Town of Erwin
Zoning Application & Permit
 Planning & Inspections Department

Permit #
 24-0098

EXISTING CONDITIONS SURVEY
 PROPERTY OF
CMH HOMES, INC.
 STEWARTS CREEK TOWNSHIP - HARNETT COUNTY - NC

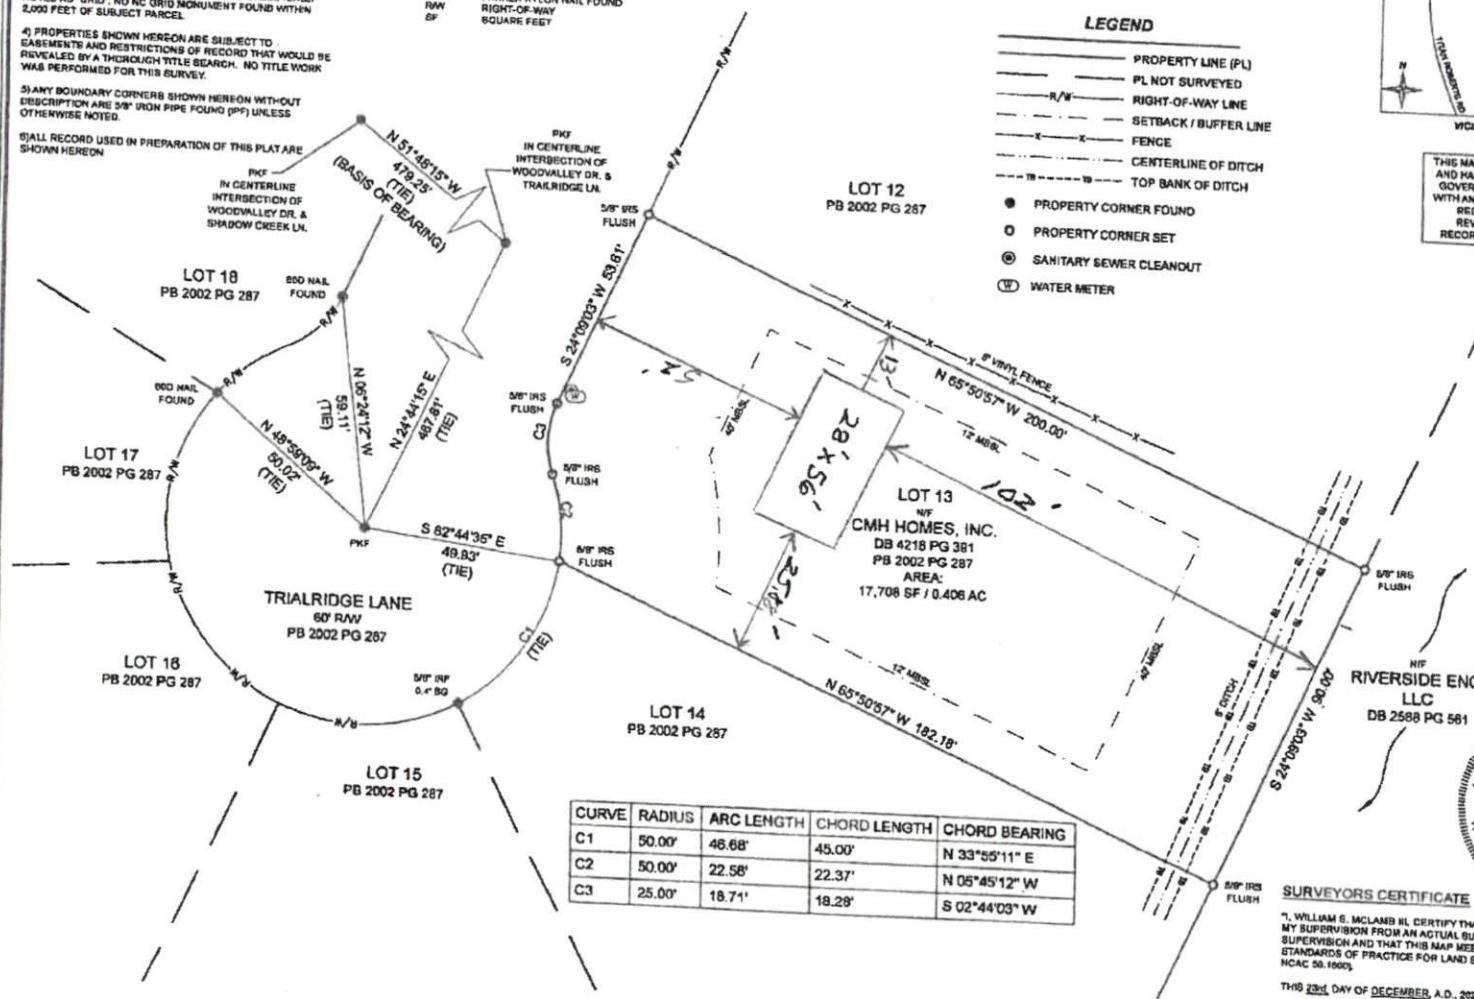
Comments: Tie downs in accordance w/ FHA (Federal housing authority) masonry underpinning / will need 4'x6' porch at entrance
